August 27, 2020

Subject: 186 Rawls Meadow Lane, Mason Pointe Subdivision Lot 57
LHD Request for Review – Session Laws 2013-413 and 2014-120
Project Number: 2020-35

PLAN:  
**240.3174-R**

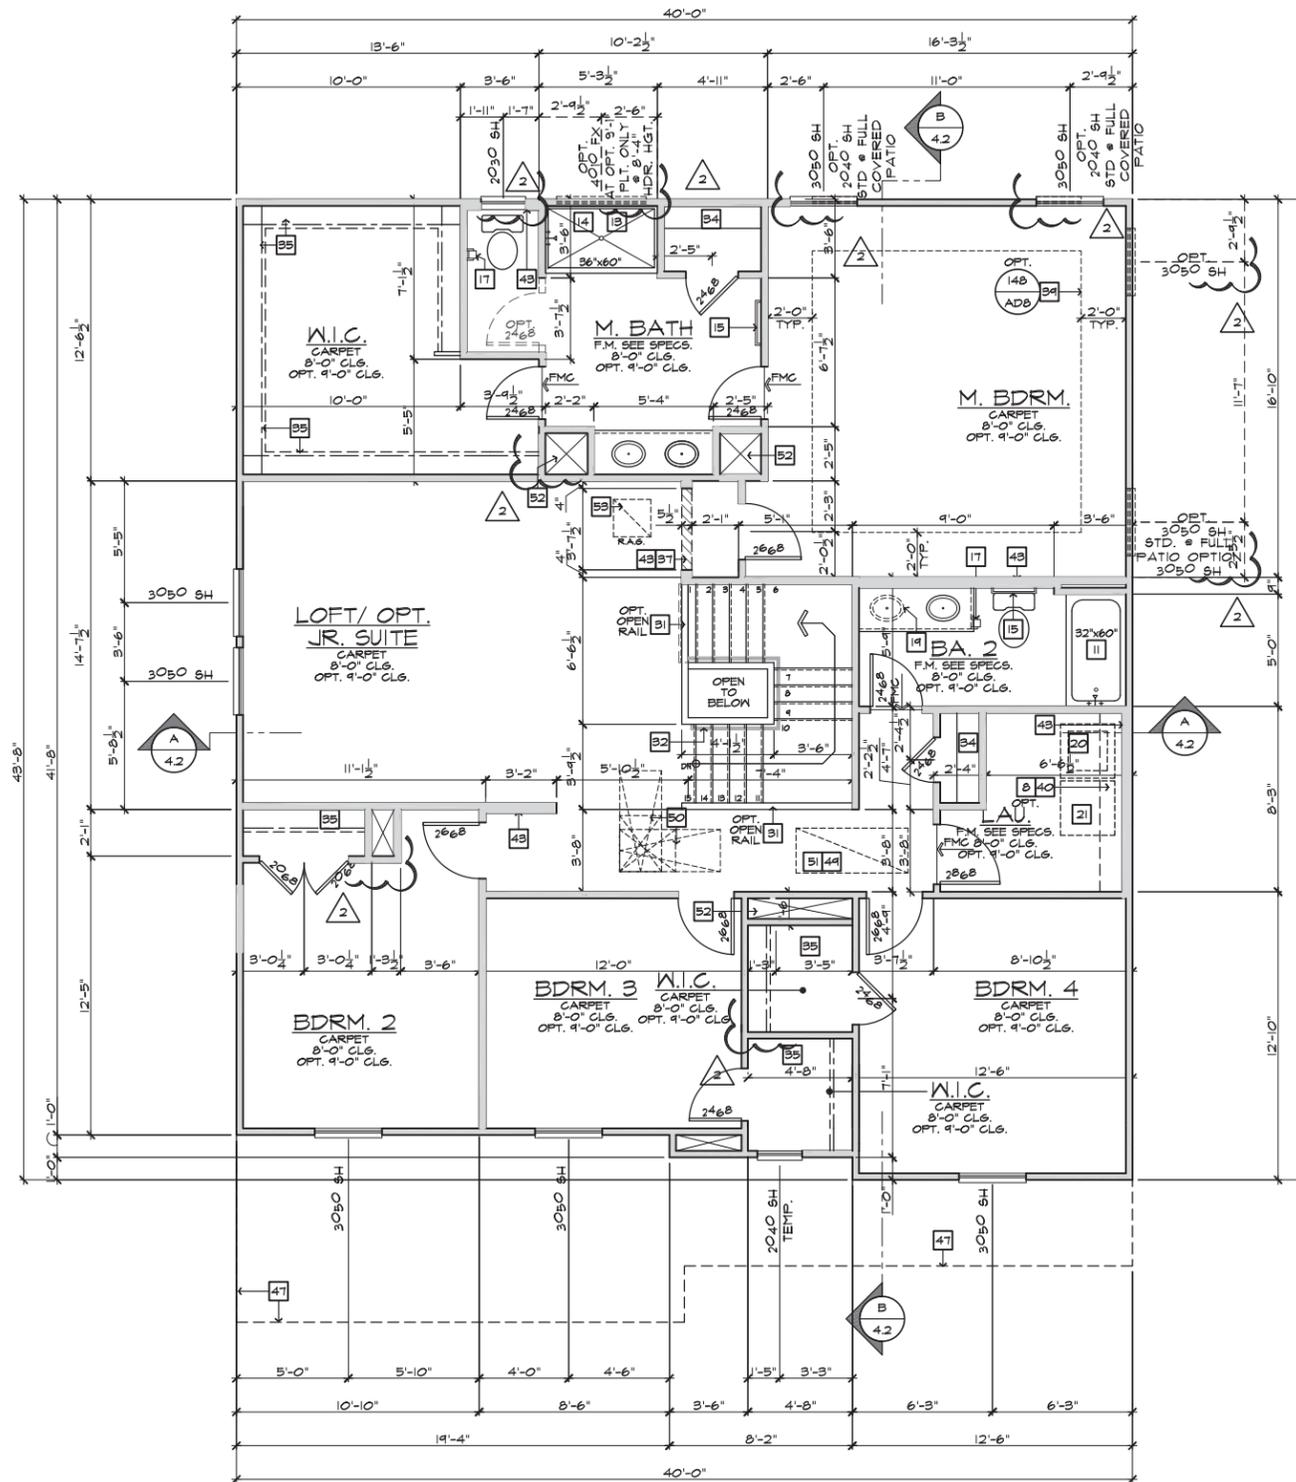
5. Observations: Floor Plan Sheets and Fixtures Table
 - a. The scale of the floor plan sheets 1.2 and 1.3 included in the submittal was so small (1" ≈ 13') that a magnifying glass was required during attempts to ascertain fixtures information on those pages. Floor plans including in future submittals are to be at a scale no smaller than 1" = 5'.

- c. A laundry sink faucet is listed in the fixtures table, but I was unable to visually identify a location of this fixture on plan sheet 1.2. Is there such a fixture in the dwelling?

**BEDROOM 5 AND BATH 3**  
AT OPTIONAL DEN AND POWDER

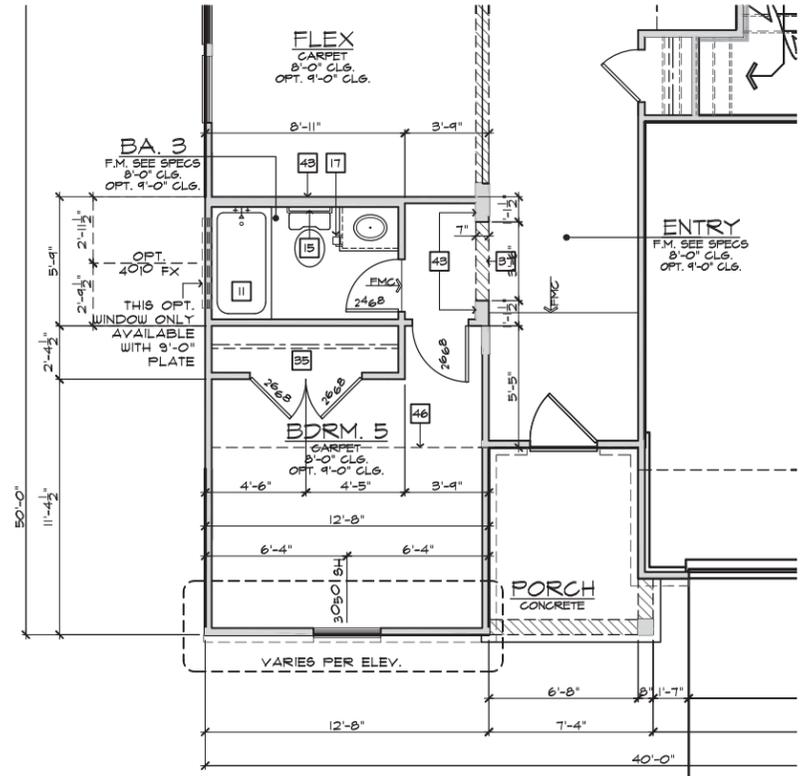
- b. The fixtures table indicates a tub/shower fixture in the Optional Bath (Bath 5), but I was unable to visually identify a location of this fixture on plan sheet 1.3. Is there such a fixture in Bath 5?
